From: Oram, Richard - Communities
Sent: 16 April 2020 14:33
To: Planning <Planning@Cherwell-DC.gov.uk>
Cc: Planning Consultations - E&E
Subject: 20/00924/DISC Bicester to Launton

20/00924/DISC Bicester to Launton

Drawing Title: **FIGURE 2A A1- ECOLOGICAL COMPENSATION SITE, CHARBRIDGE LANE**

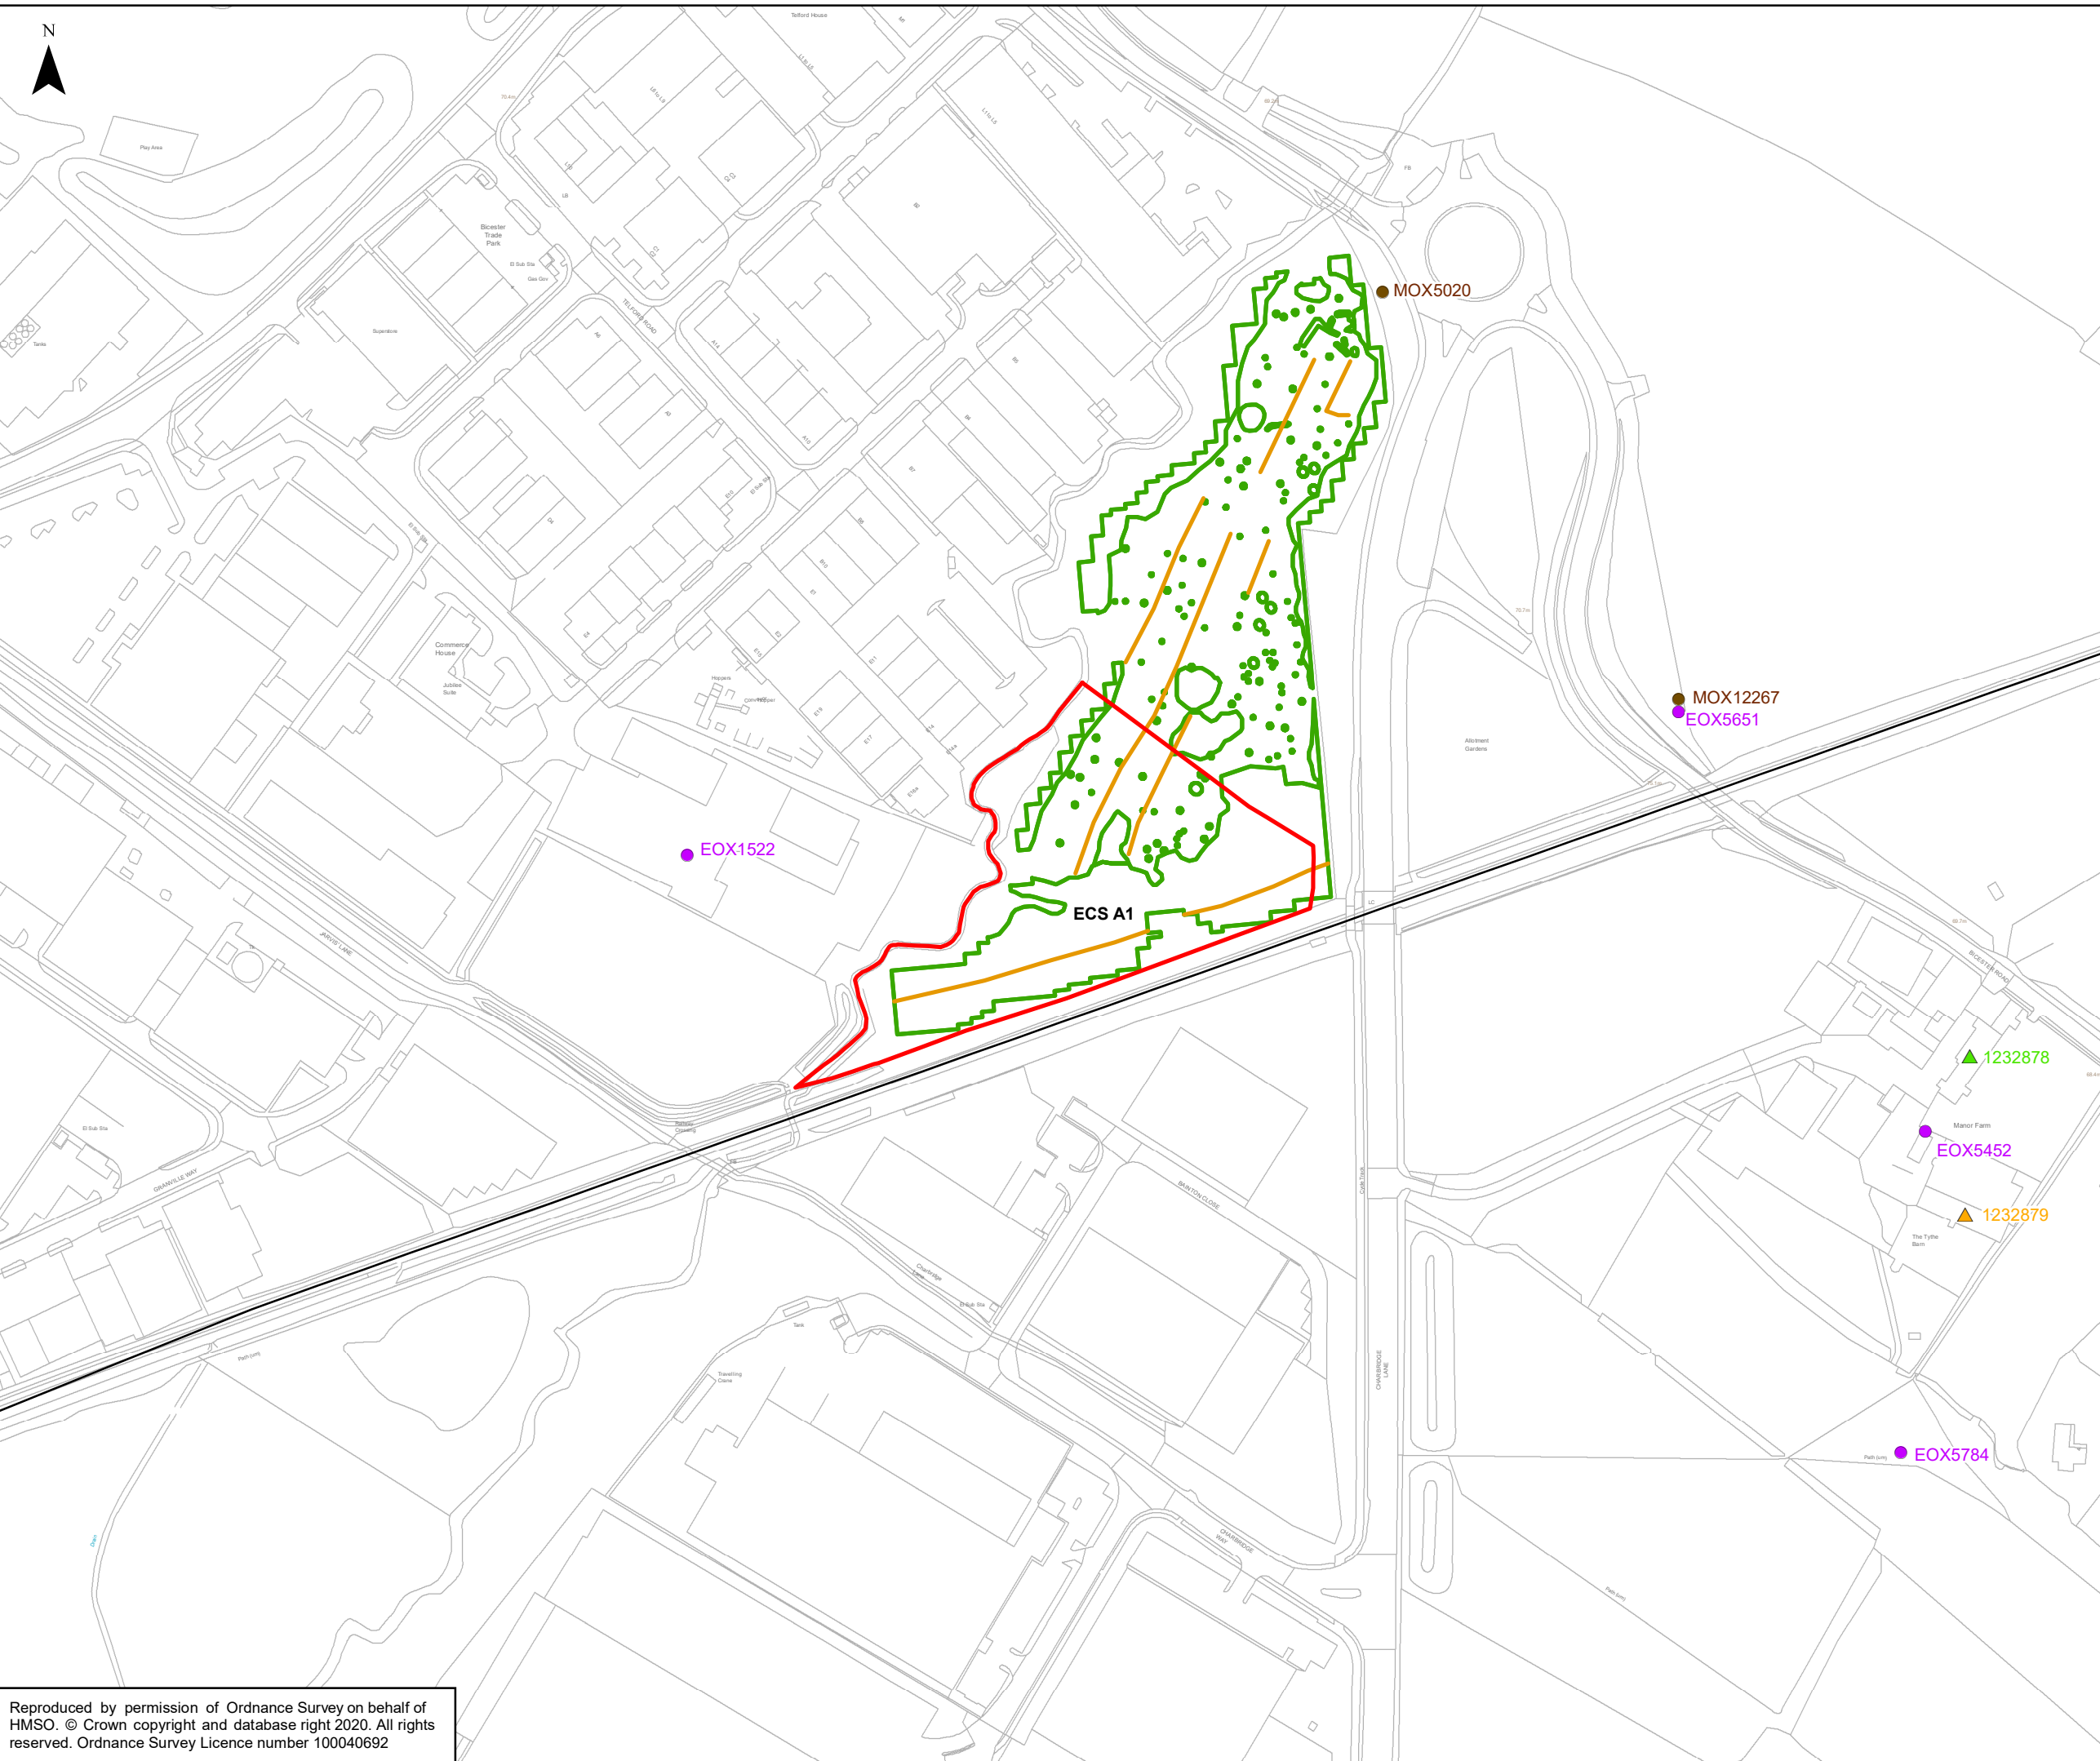
The WSIs titled '2A A1_Charbridge Lane ECS WSI Issue for Approval' and '2A0061-5.5-FH_Charbridge Lane ECS WSI Issue for Approval' are for Ecological Compensation Sites but only include a plan of the red line area. There is no indication within these WSIs as to what the works subject to the watching brief would actually consist of or the area within the red line boundary that will be monitored.

This detail will need to be included in these site specific WSIs as set out in the Chartered Institute for Archaeologists standards and guidance for archaeological watching brief.

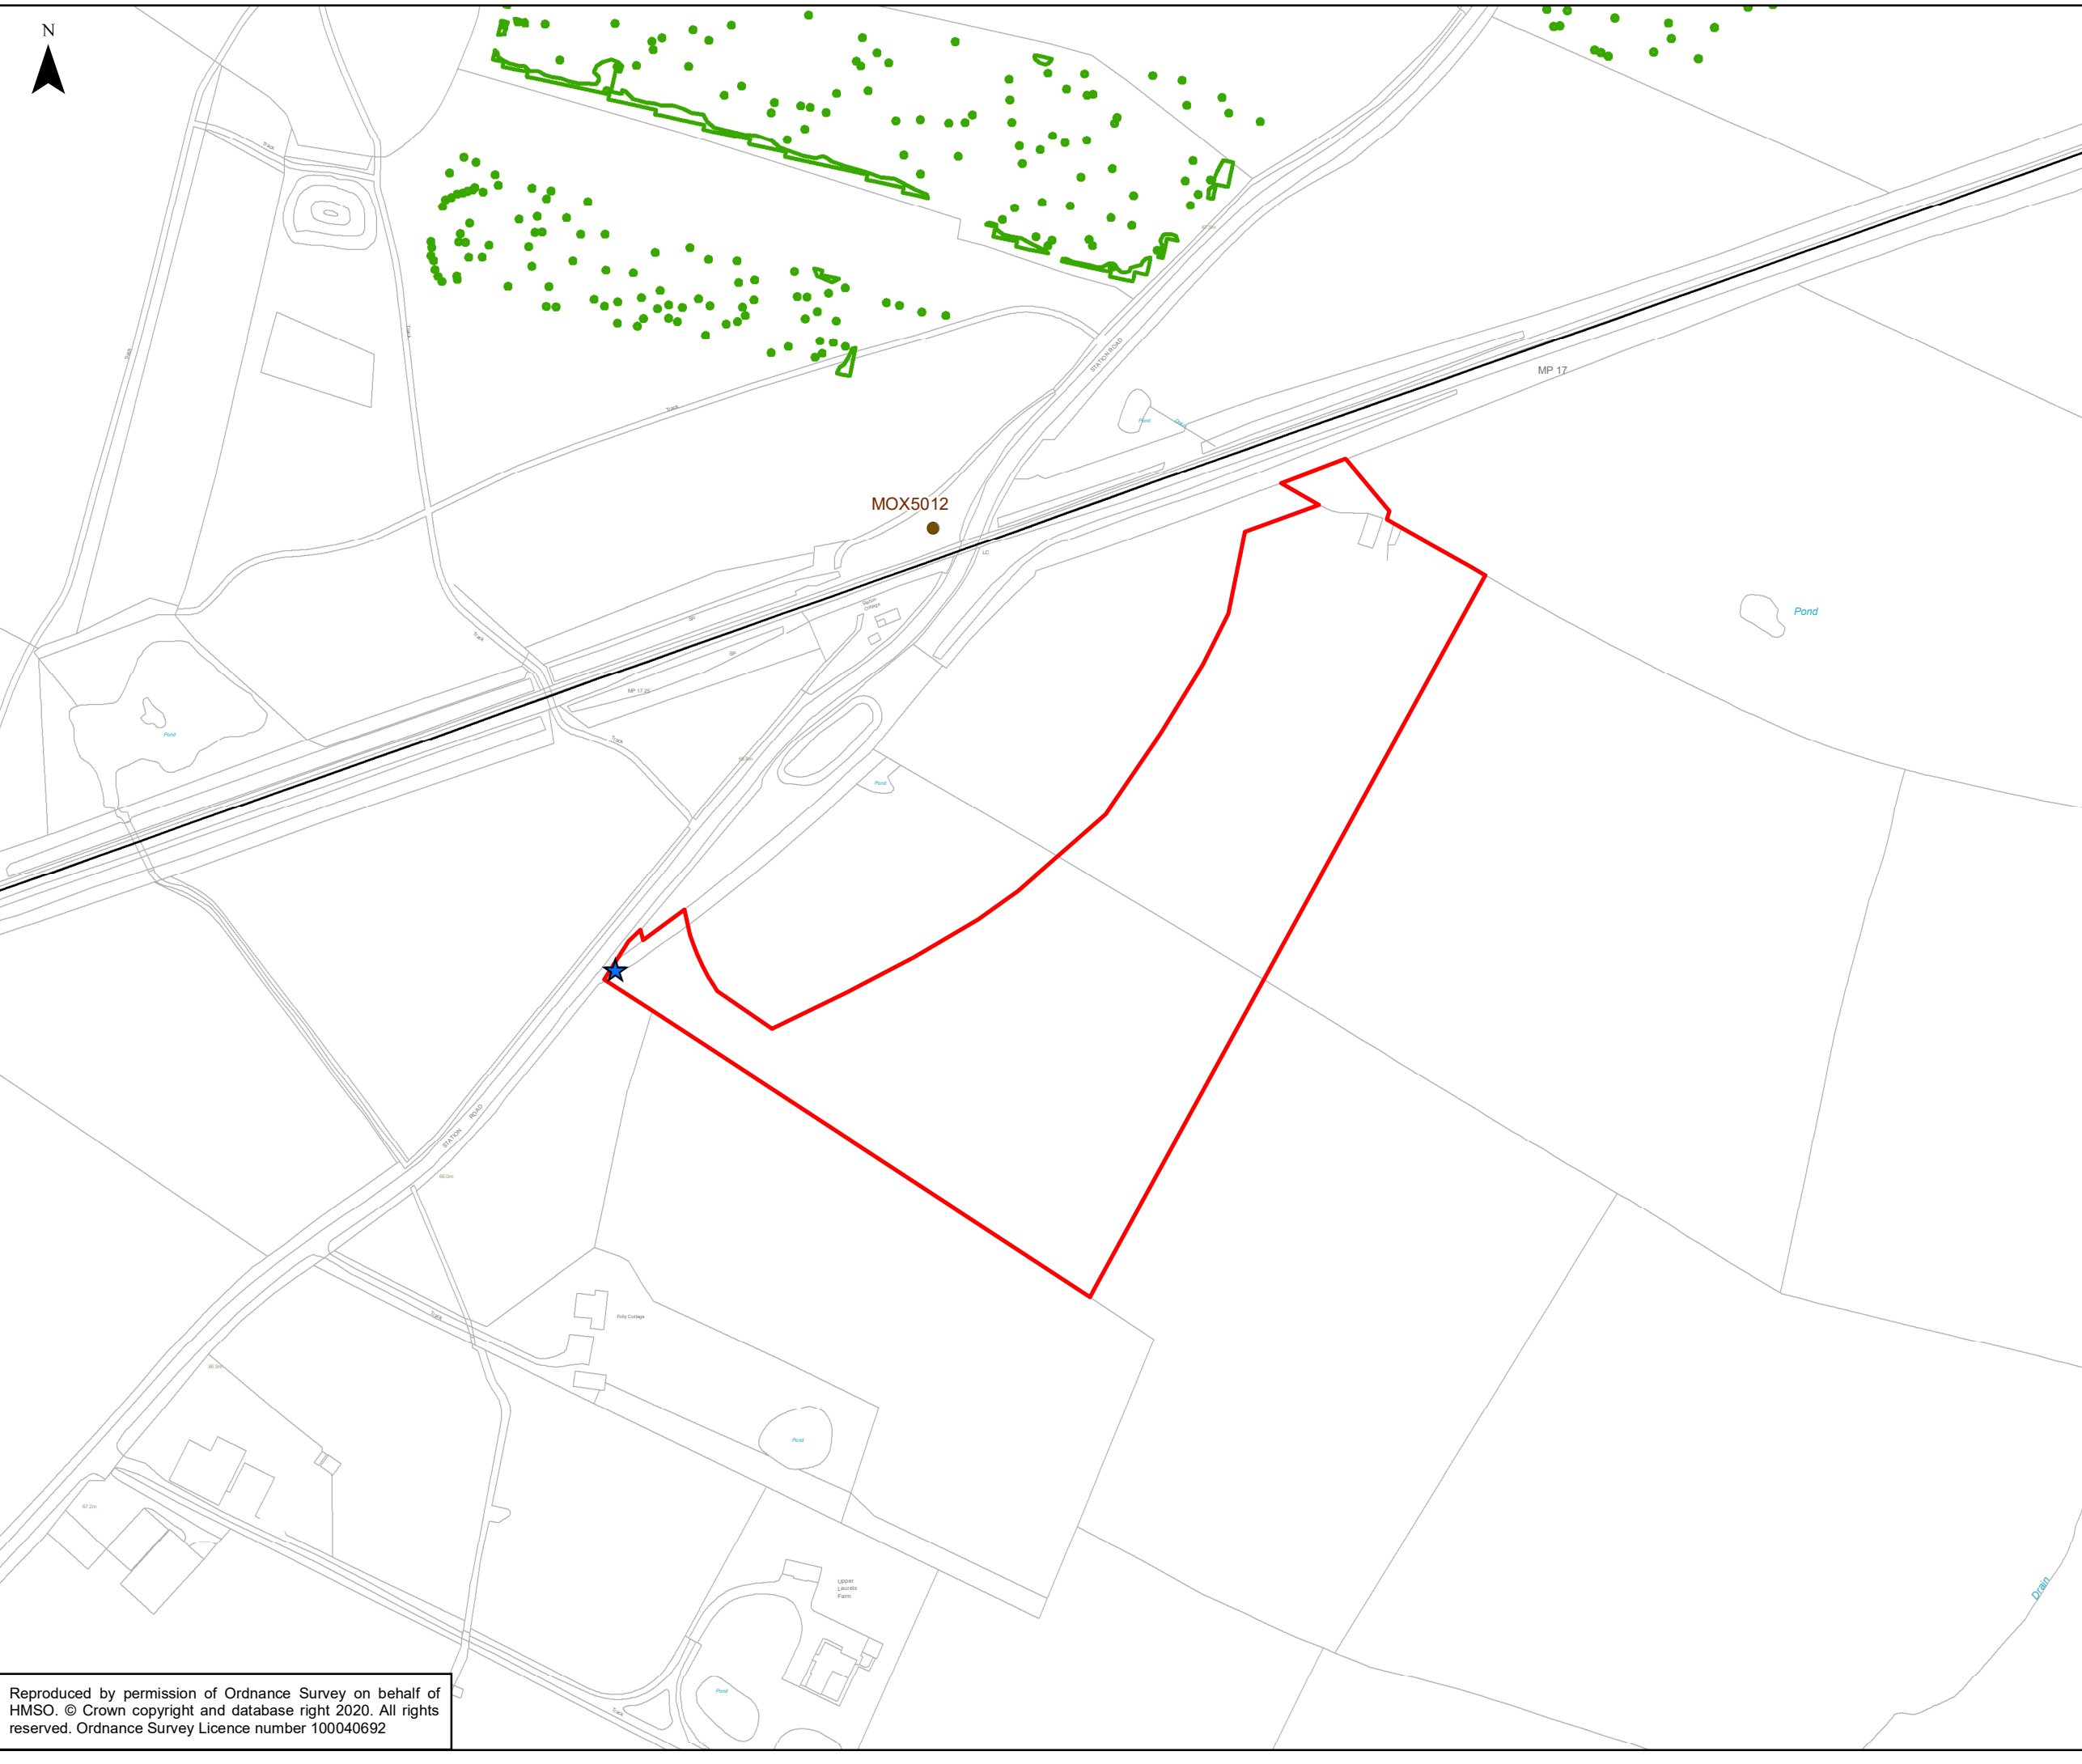
The WSI for the strip map and sample titled 'EWR2 Condition 9(b) WSI - 2A2 Compound Access' has similar issues. The WSI contains no detail on the area subject to the excavation or any details on the monitoring arrangements, notice periods, sign off arrangements which would normally be expected in a WSI for this purpose.

This detail will need to be included in this site WSIs as set out in the Chartered Institute for Archaeologists standards and guidance for archaeological excavation.
